**Re: Tiburon Heights
Erosion and Sediment Control Plan
Engineer's Stamp Date 11-8-18 (D10E003A)**

Based upon the information provided in your submittal received 11-9-18, the above referenced plan is approved to be included in the SWPPP and for NOI review for grading and Building Permit with the following condition:

TEMPORARY EROSION AND SEDIMENT CONTROL PLAN

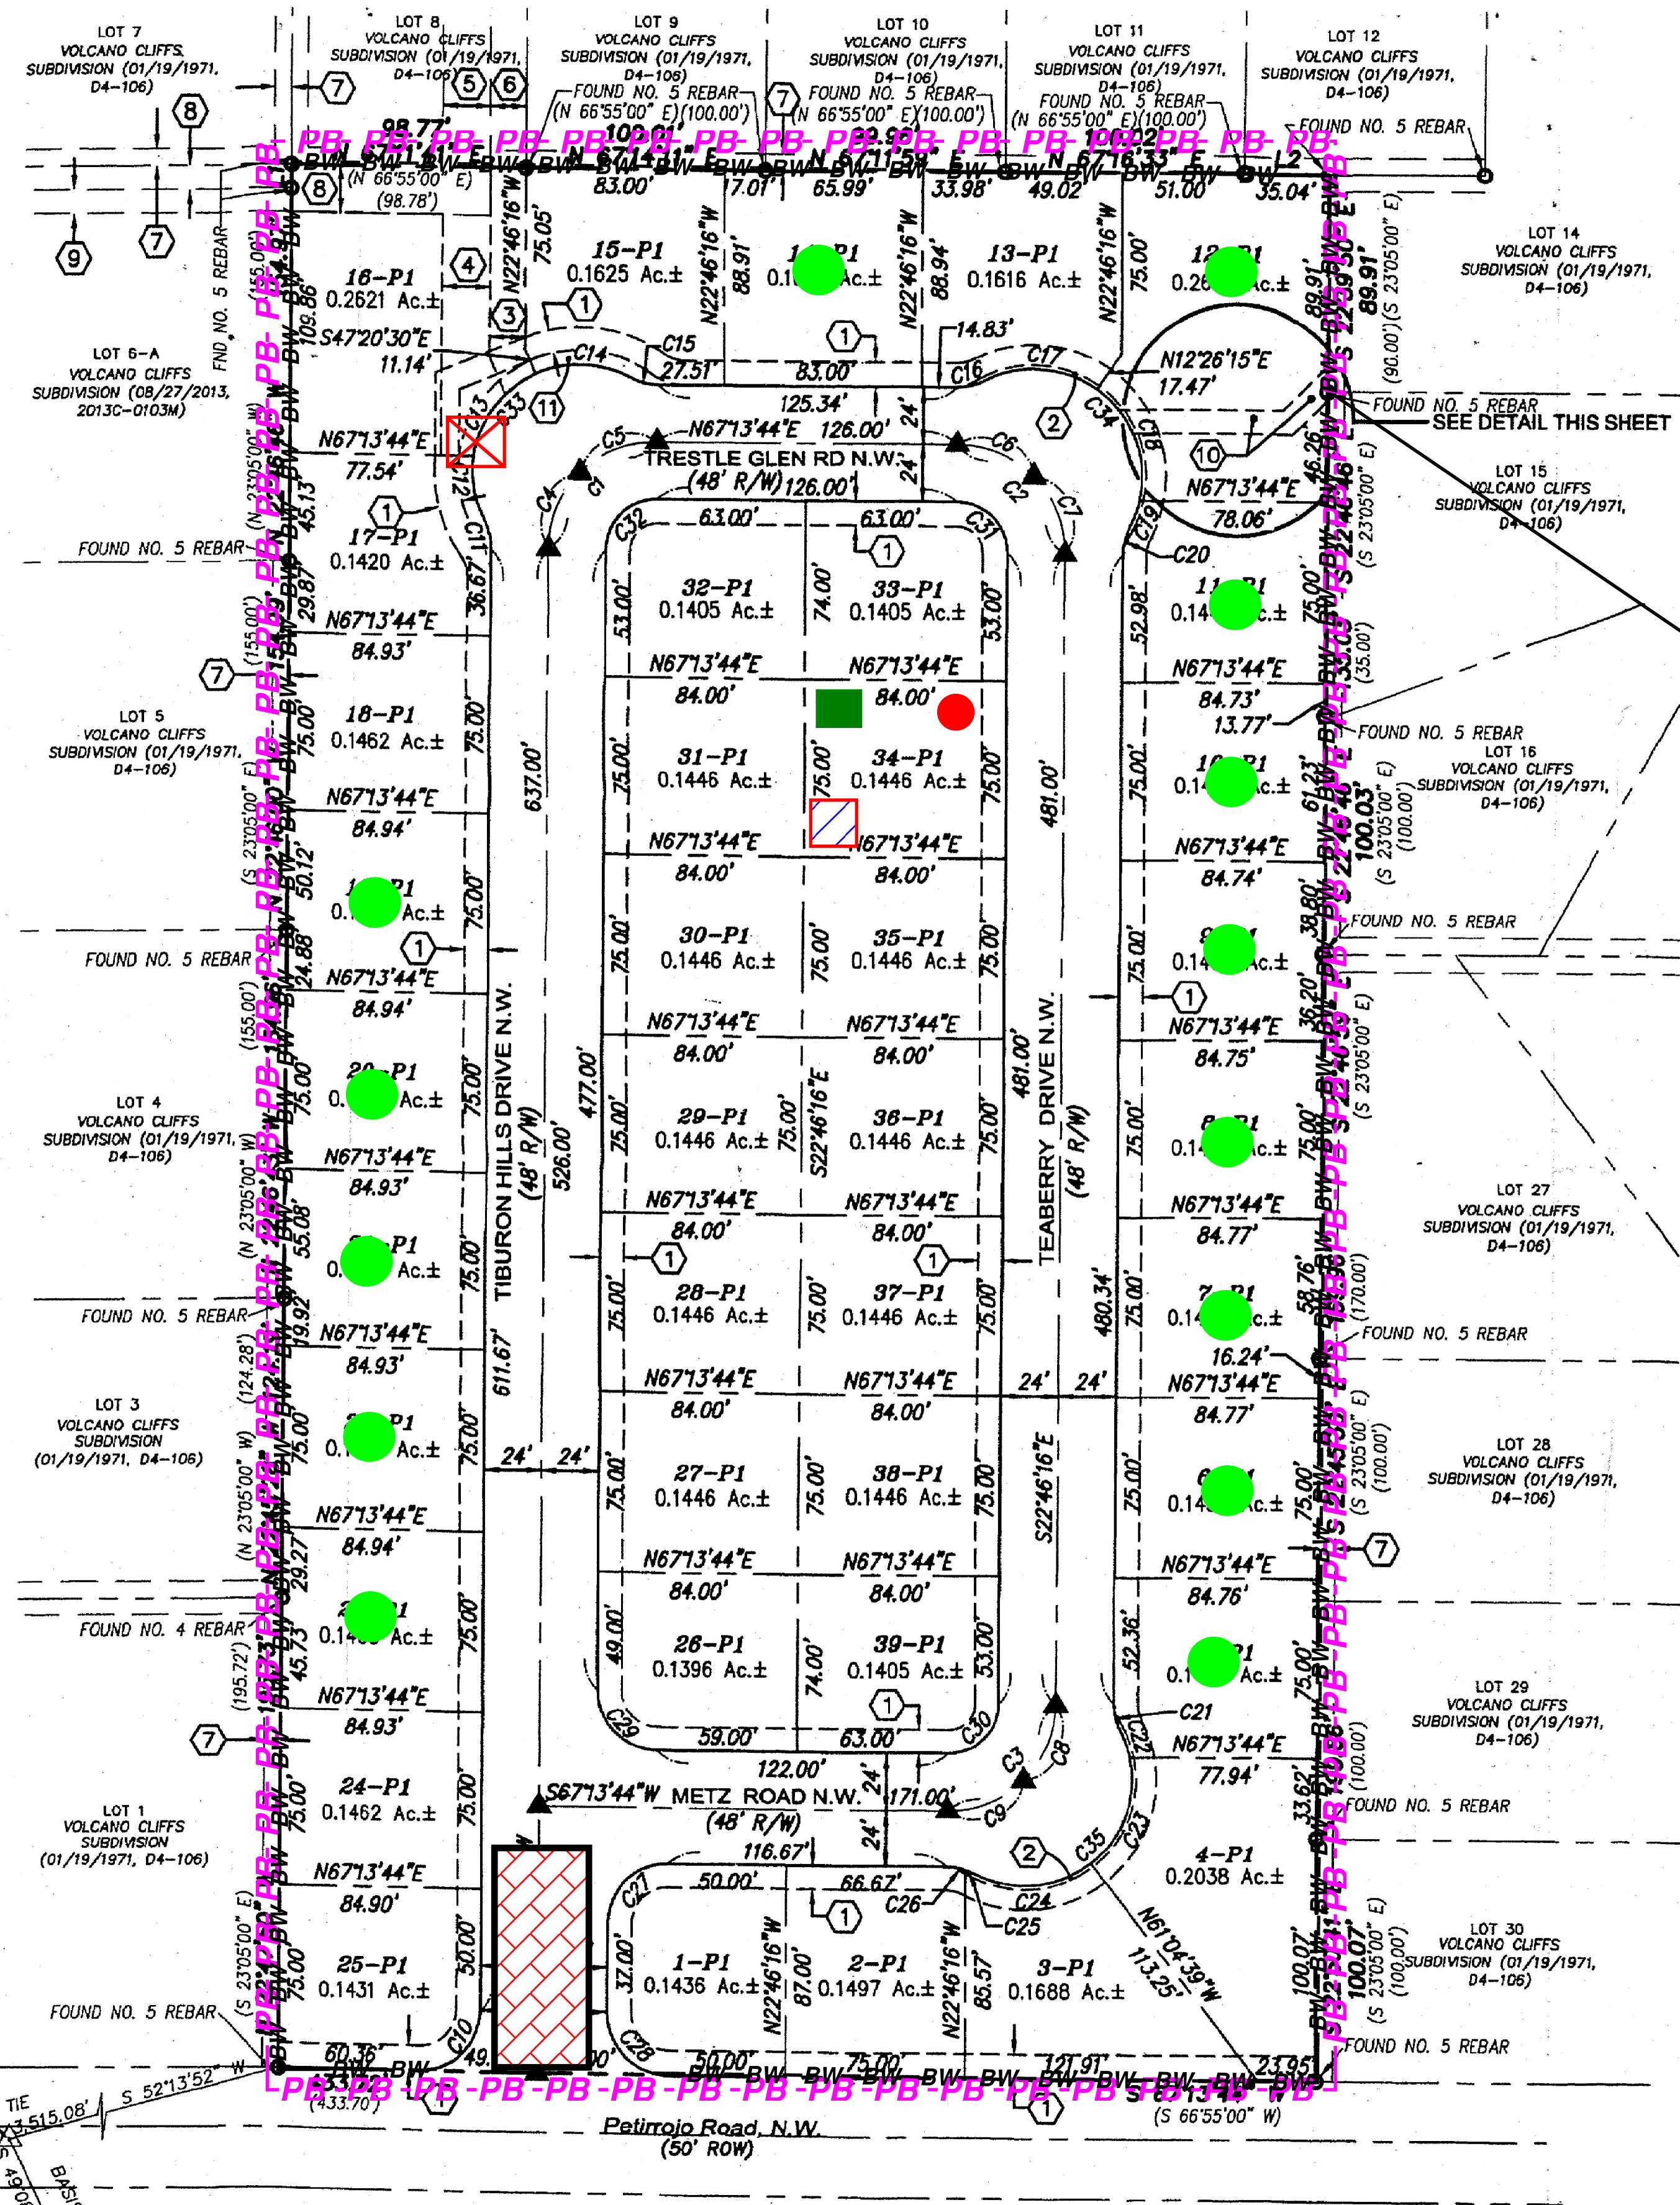
1. All lots, unless stabilized, are to have a sediment BMP behind the curb in the front of the lot. Most Operators at single family residential projects are using the cutback behind the curb.
